**KIRKLEES METROPOLITAN COUNCIL
INVESTMENT & REGENERATION SERVICE**

DELEGATED DECISION TO DETERMINE PLANNING APPLICATIONS

Reference No:	2024/62/93351/E
Site Address:	35, Pinfold Lane, Mirfield, WF14 9HZ
Description:	Erection of single storey rear extension and part first floor extension with extended dropped kerb and parking area to front
Recommending Officer:	Faiza Bano

HOUSEHOLDER DELEGATED REPORT

REAR ELEVATION
(South West)

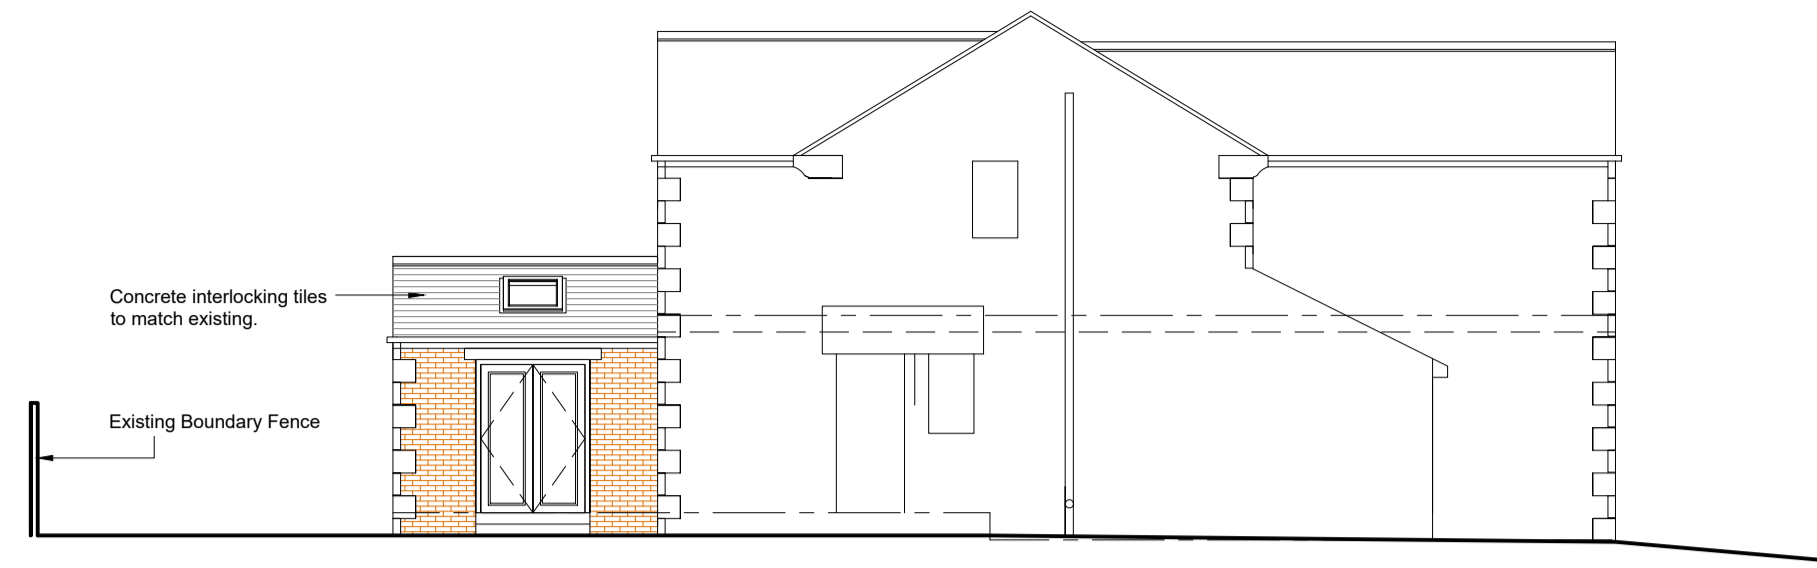
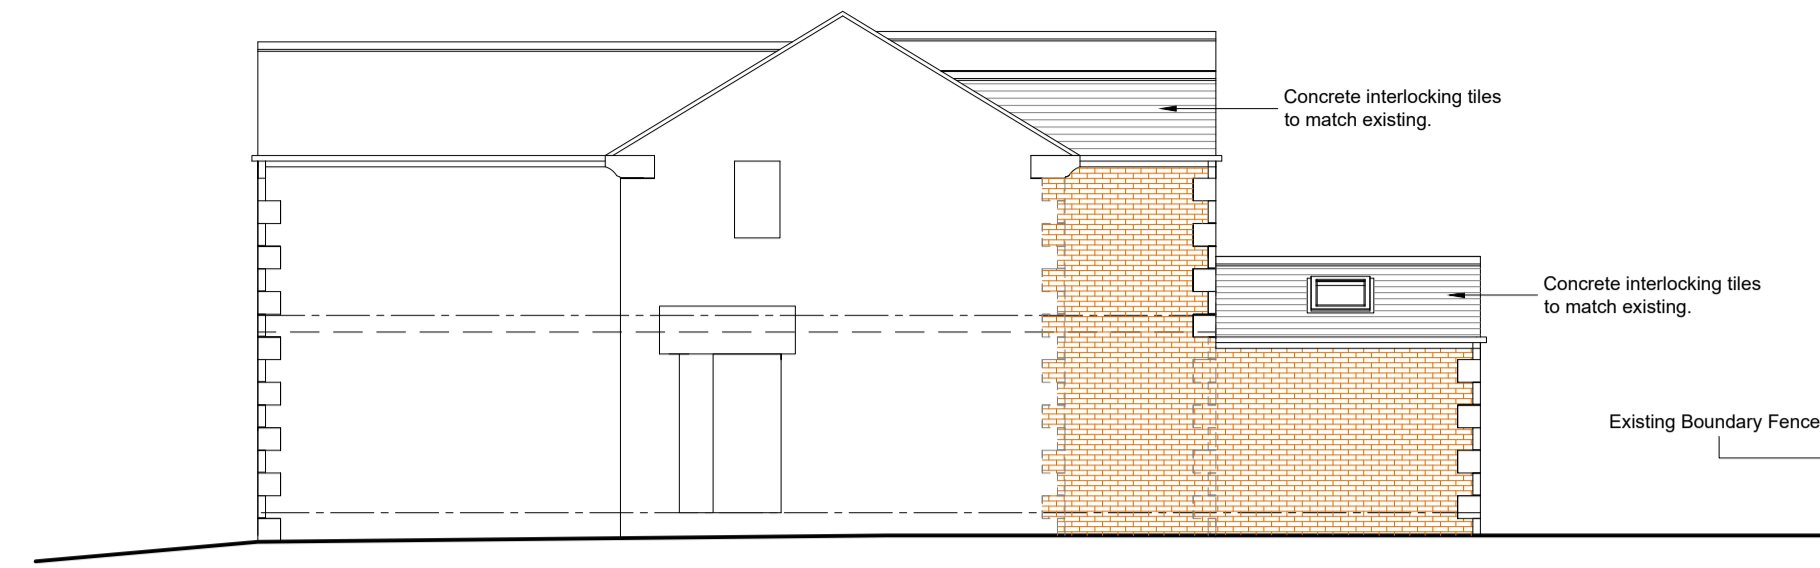
Two Storey Rear Extensions Should:	<u>Yes - COMPLY</u>	<u>No - JUSTIFY</u>
be proportionate to the size of the original house and garden;	Yes – the proposed two-storey extension projects out by approximately 2 metres and has a width of approximately 3.1 metres. The proposed extension is an infill and due to the detached nature of the dwelling it is considered proportionate and acceptable.	
not normally exceed 50% of the total area of land around the original house (including previous extensions and outbuildings);	Yes – the extension does not cover more than half of the total area around the original house.	
not project out more than 3 metres from the rear wall of the original house or by 4 metres for detached properties;	Yes - The proposed extension projects out by approximately 2m which is in keeping with the SPD. Ample garden space will be retained to the rear of the house.	
not exceed a height at the eaves of 3 metres where the extension is within 1.5 metres of the property boundary;		No – the extension has an eaves height of 4.8 metres. Considered acceptable due to being an infill and in line with the

rear boundary line of number 37.
be separated from the property boundary, such as a wall, fence or hedge, by at least 1.5 metre; and		No – the extension is approximately 1 metre away from the boundary. However, this extension is considered acceptable due to it being in line with the rear building line of number 37 – and does not interfere with the 45 degree rule.
not adversely affect habitable room windows where they adjoin a neighbour's boundary	Yes – the two-storey extension is designed to retain a gap from the boundary and does not cause any issues in terms of loss of outlook and overshadowing.

Rear Extensions Should:	<u>Yes - COMPLY</u>	<u>No - JUSTIFY</u>
respect the original house and garden in terms of its size and scale	Yes – the extension does not cover more than half of the total area around the original house. The proposed extension projects out by approximately 3.3m. The proposed development would have an eaves height of 2.5m, which is acceptable due to the detached nature of the dwelling. Ample garden space will be retained to the rear of the house.	
use appropriate materials which match or are similar in appearance to the original house; and	Yes - to match existing	
not have an adverse impact by way of overshadowing or loss of outlook of neighbouring properties.	The proposed extension will not overshadow neighbouring properties. Due to the detached nature to the site and

- 37 Pinfold Lane – The proposed two storey rear extension does not surpass the building line of the rear elevation of this property and the single storey extension meets the 45 degree rule. As such no significant issues would arise from overlooking, overshadowing/loss of light or overbearing impact.
- 33 Pinfold Lane – This property is located to the opposite side of proposed works and shall see the addition of a rear projections to the existing dwelling, as such no significant issues would arise from overlooking, overshadowing/loss of light or overbearing impact.
- There are properties to the rear, however, the proposed extension is the set back from the boundary and it will not impact the properties behind.

PROPOSED SITE PLAN
@ 1 : 100

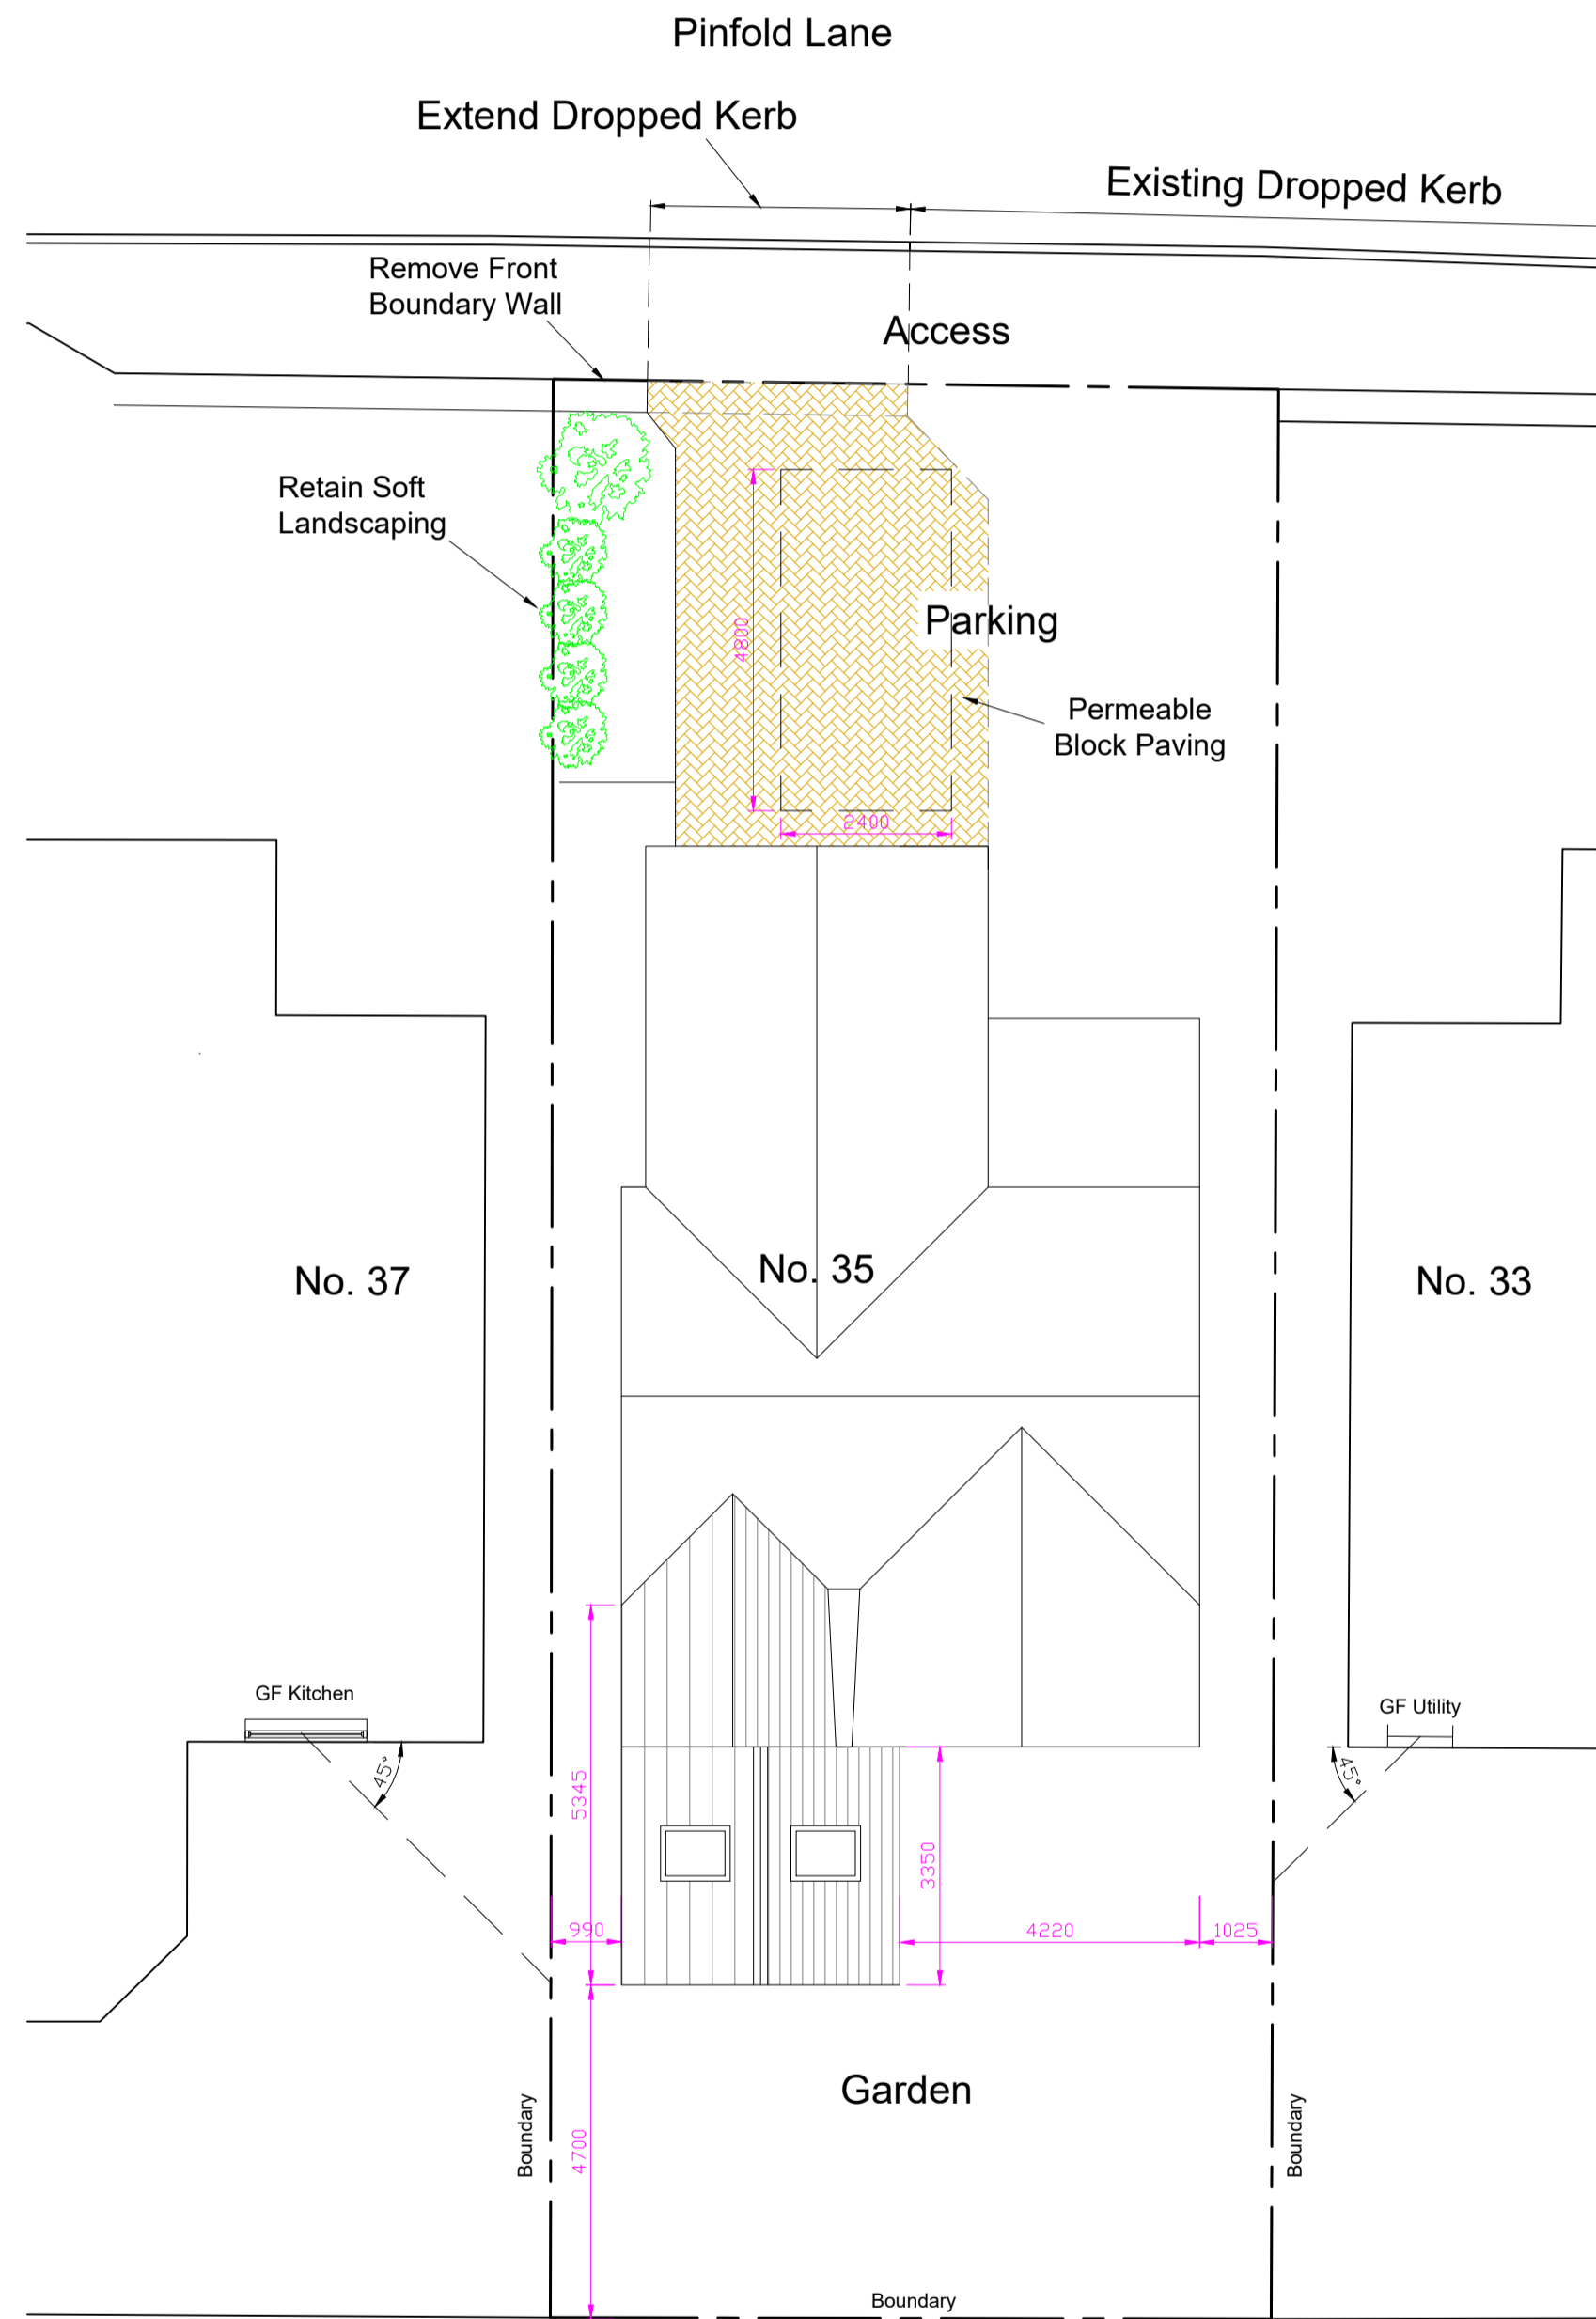
The application also seeks permission to extend the dropped kerb to provide additional in curtilage parking.

The proposal would essentially maintain the existing visual impact of the site, particularly regarding the hard-surfaced front amenity space. The removal of the front boundary wall and the creation of a dropped curb are not considered to have a significant or out-of-character visual impact within the street.

Impact on original house	<ul style="list-style-type: none"> • KDP2 of the SPD • Policy LP24 Design (c) and (d) of the KLP • Chapter 12 of the NPPF 	<p>The original property would remain the dominant feature.</p> <p>Dropped kerb - The proposed alteration will have no significant effect on the original property. The impact will be limited to the front amenity space, which is currently entirely hard standing.</p>	✓
Height, scale and massing	<ul style="list-style-type: none"> • KDP 1 and 2 of the SPD • Policy LP24 Design (a), (c) and (d) of the KLP • Chapter 12 of the NPPF 	<p>As above. The extension would project across the rear of the property. The proposed development consists of a single-storey and a two-storey extension to the rear.</p>	✓
Facing materials and detailing	<ul style="list-style-type: none"> • KDP 9 of the SPD • Policy LP24 Design (d) (iii) of the KLP • Chapter 12 of the NPPF 	<p>Facing materials to match existing.</p> <p>Dropped kerb - Given the variety of materials used at the front of neighbouring properties within the street scene, and considering the existing visual impact of the host property being hard surfaced, the front amenity space is deemed acceptable.</p>	✓

Relevant key design principle (KDP) of the SPD, Policy in the Kirklees Local Plan and the NPPF	Further comments	✓ / X / N/A
Impact on highway safety	<ul style="list-style-type: none"> • KDP 15 of the SPD • Policy LP22 Parking (f) of the KLP • Chapter 12 of the NPPF 	Parking is predominantly provided on-street and in curtilage, which remains acceptable due to the location of this property and the neighbouring houses – off the main through-fare. The property also has a driveway big enough to fit a car after the construction of the proposed extension.	✓
Parking provision	<ul style="list-style-type: none"> • KDP 15 of the SPD 	Maintains appropriate access and off-street in-curtilage parking.	✓
